# CITY OF ALBUQUERQUE

February 16, 2024

**Re: Markana Flats**  
**7050 Constitution Ave. NE**  
**Traffic Circulation Layout**  
Architect's Stamp 08-16-23 (J19-D047A)

Based upon the information provided in your submittal received 02-09-24, the above referenced plan cannot be approved for Building Permit until the following comments are addressed:

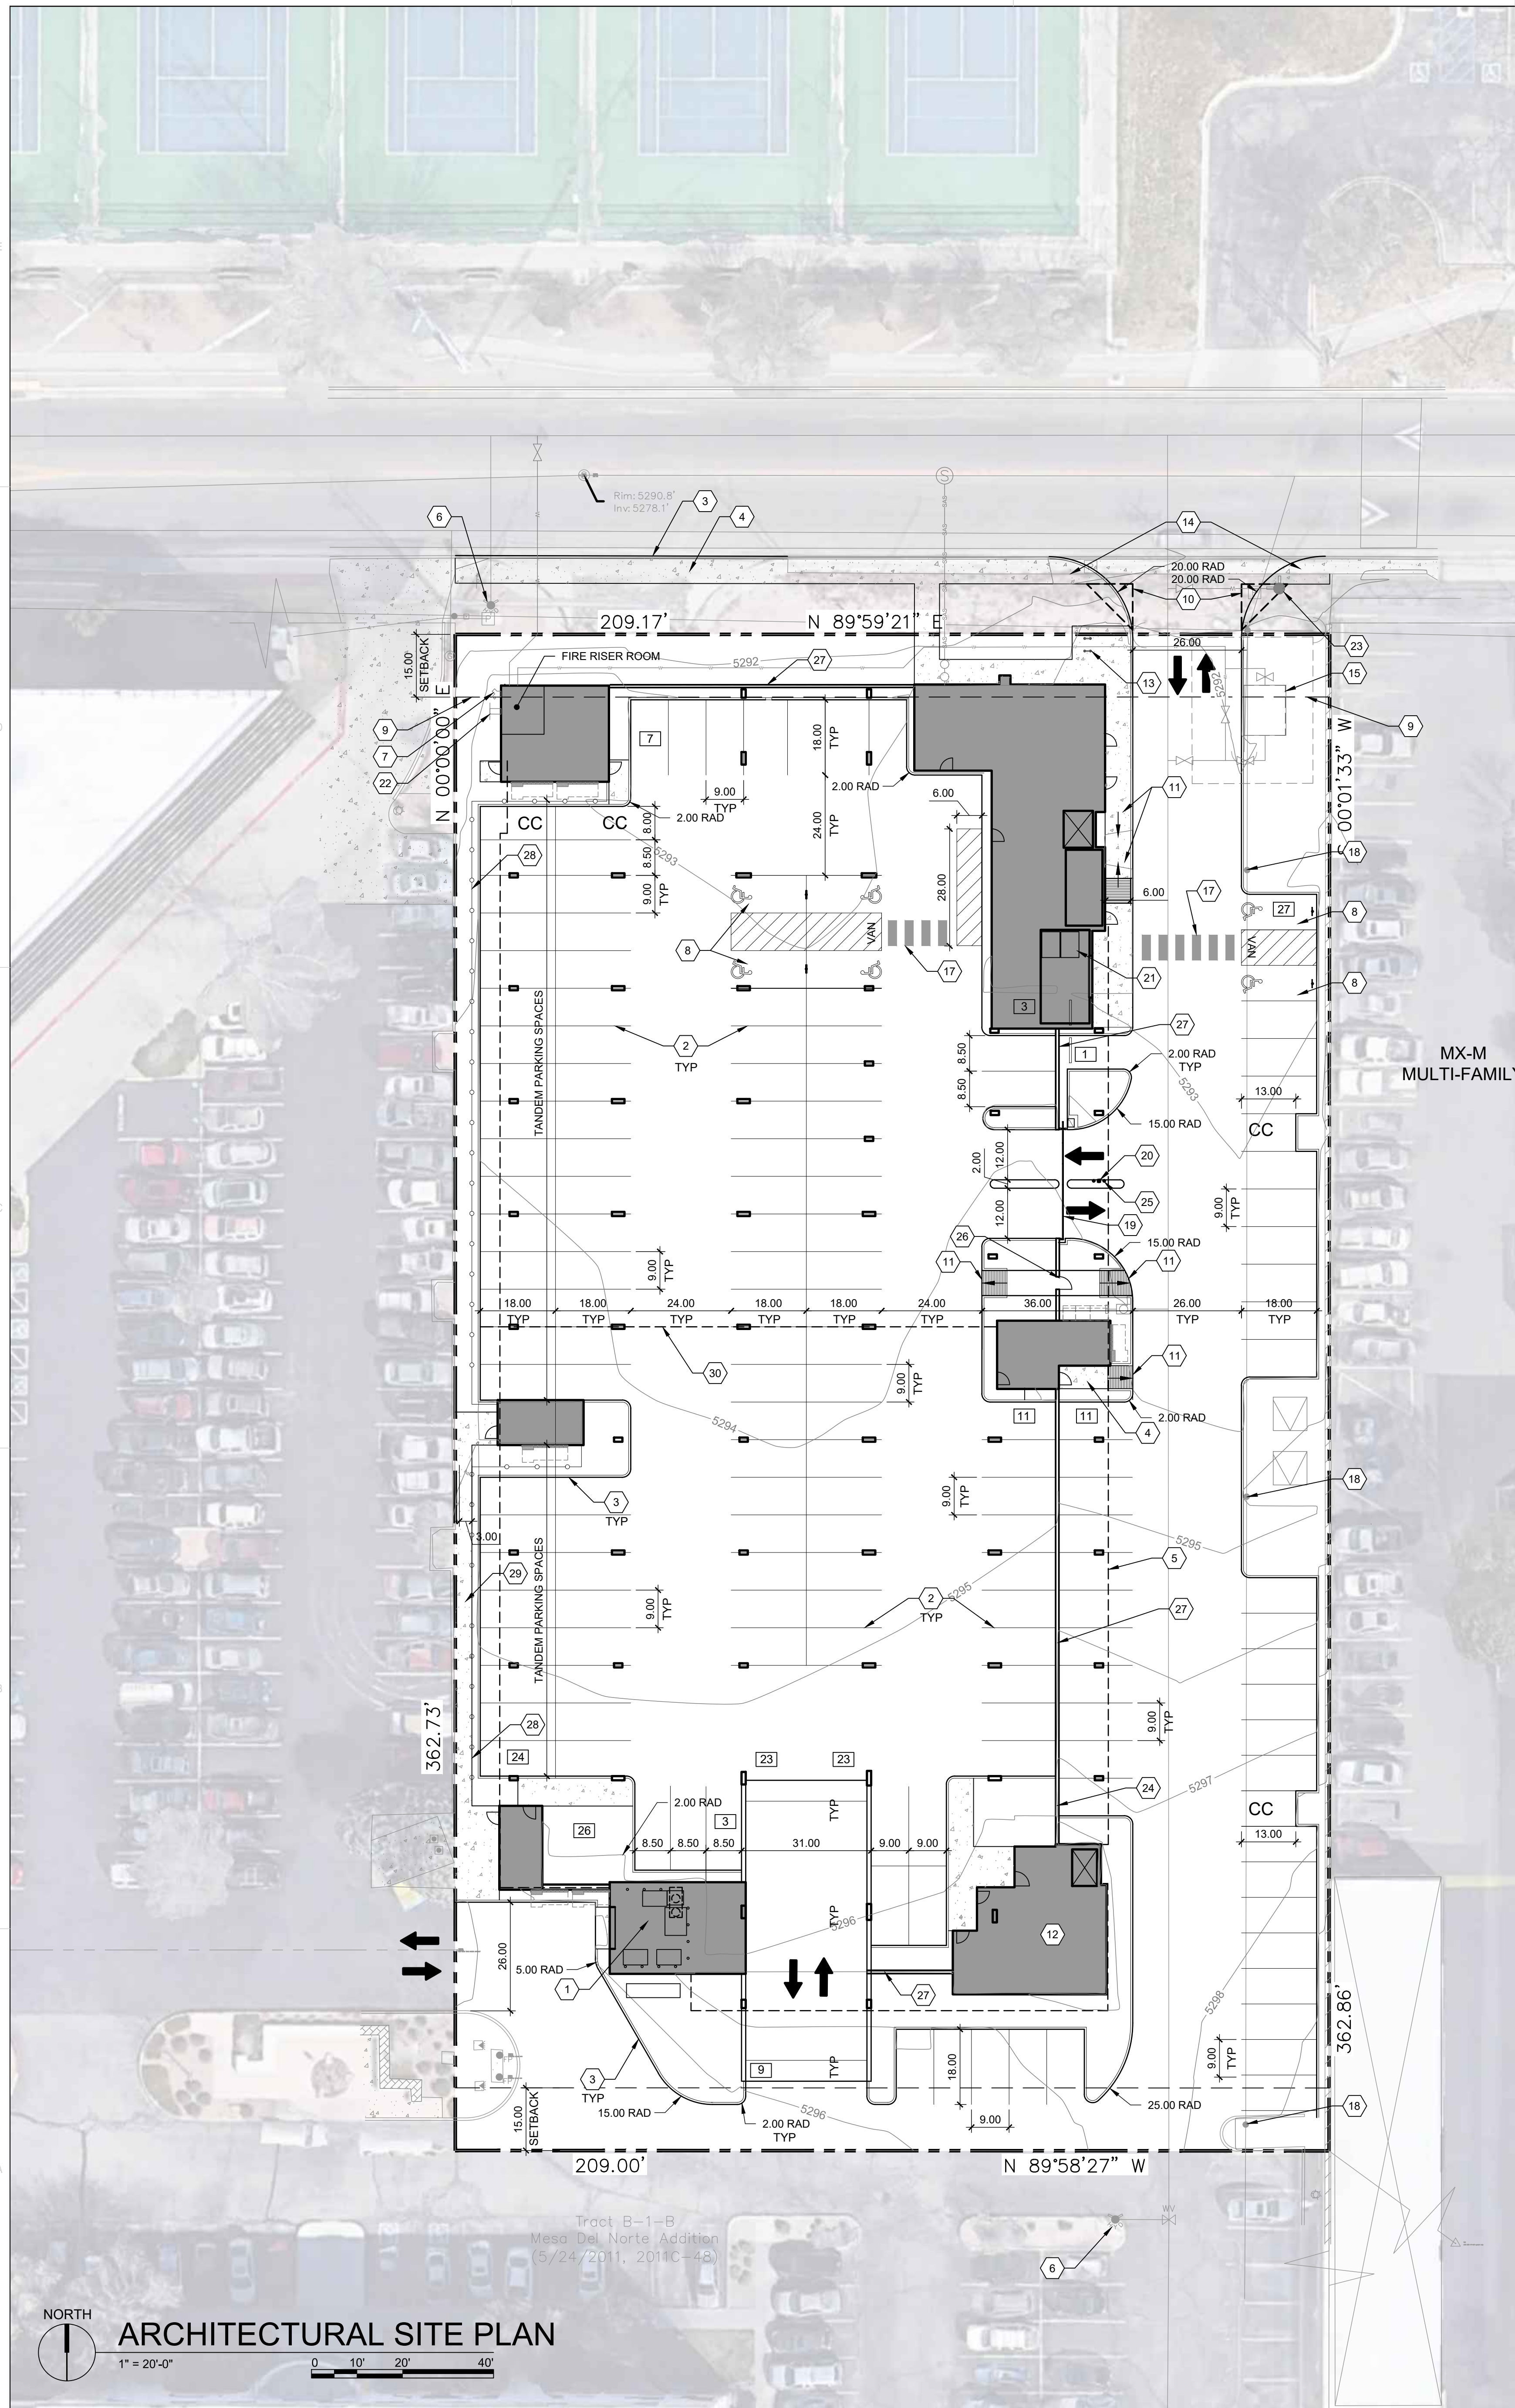
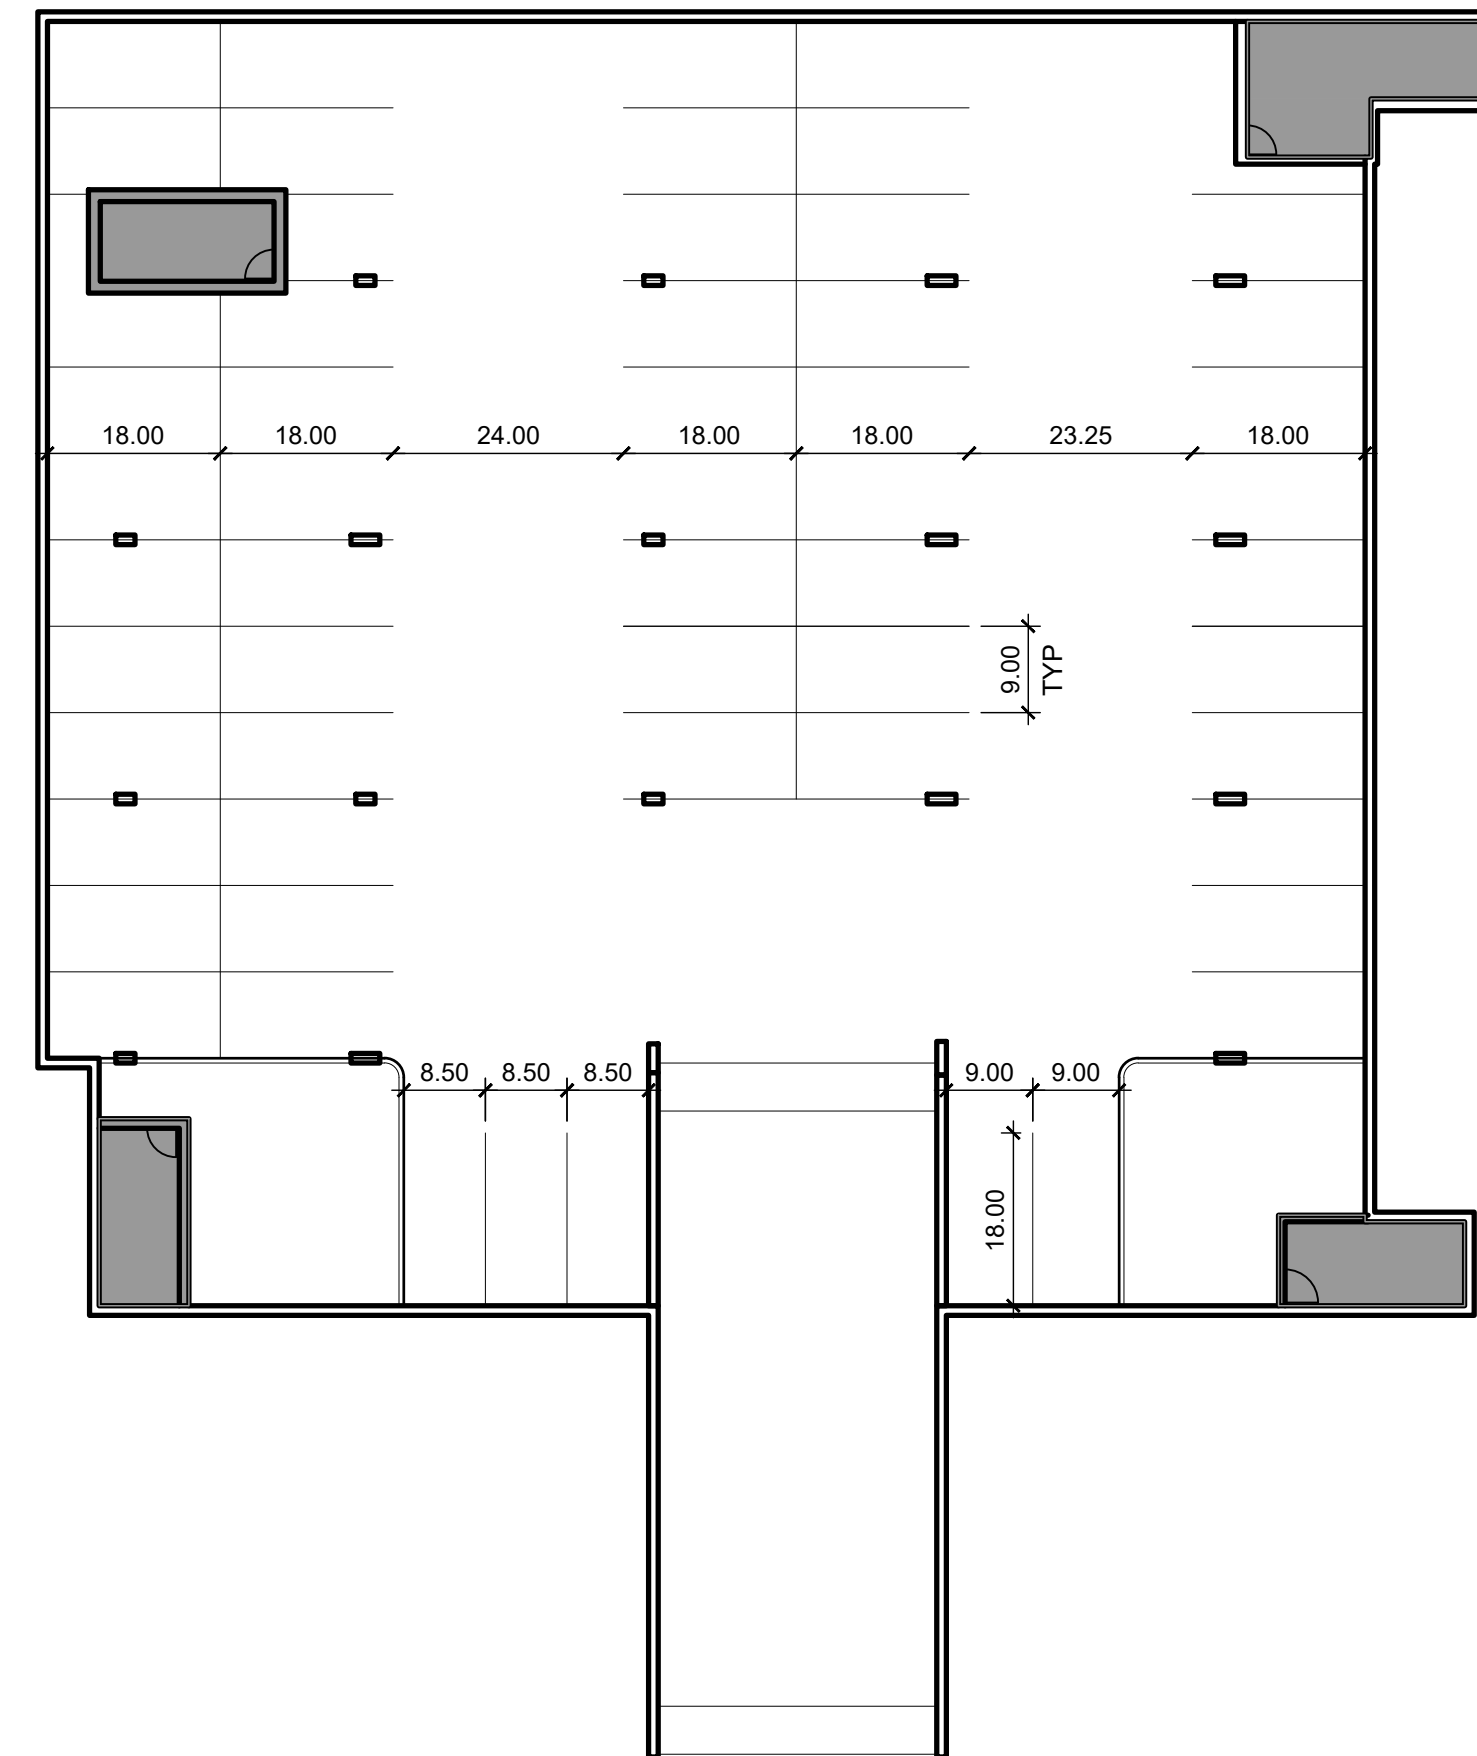
1. Please provide a clear copy of the approved recorded easement, as the one you provided is blurry and unreadable.
2. Per Google aerial view, there are power poles on the east side of the site. Please show those poles on the site plan and provide an easement.

3. Please explain how the Tandem Parking spaces will be managed?
4. Show on the parking table requirement, how many Motorcycle and EV parking space are required.

6. Keynote 10: please show on the site plan the dimensions of the clear sight triangle.
7. A 5 ft. keyway is required for dead-end parking aisles for the lower level plan.

8. Please show on the site plan how wide is the concrete columns to ensure that they do not impact the width of the proposed parking spaces.
9. Please clarify whether the ADA pathways from the ADA aisles to the building entrance are flush all the way long.

10. Label the compact parking spaces by placing the words "**COMPACT**" on the pavement of each space.
11. Keynote 27: Parking areas shall have barriers to prevent vehicles from colliding with the wall/ fence.

A5 ACCESSIBLE PARKING
1/8" = 1'-0"

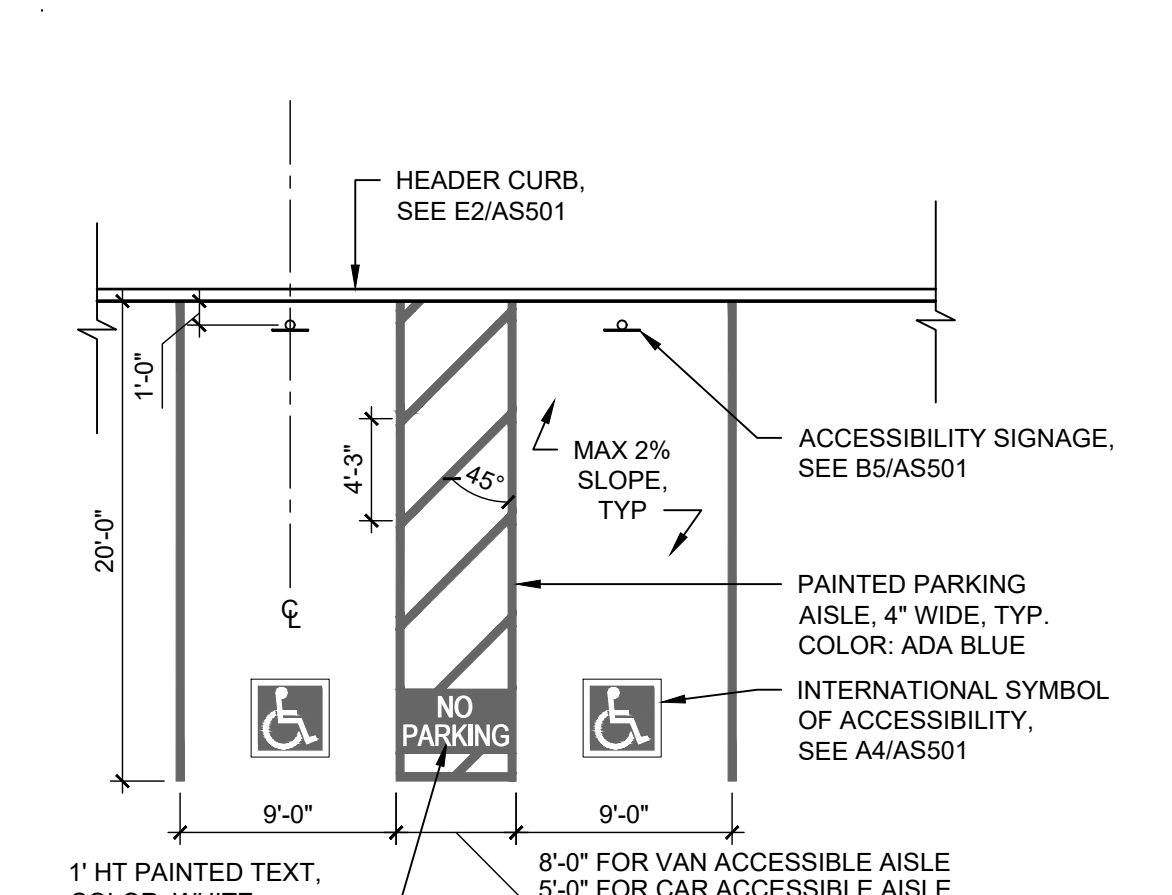
5. The ADA accessible parking sign must have the required language per 66-7-352.4C NMSA 1978 **"Violators Are Subject to a Fine and/or Towing."** Please call out detail and location of signs.
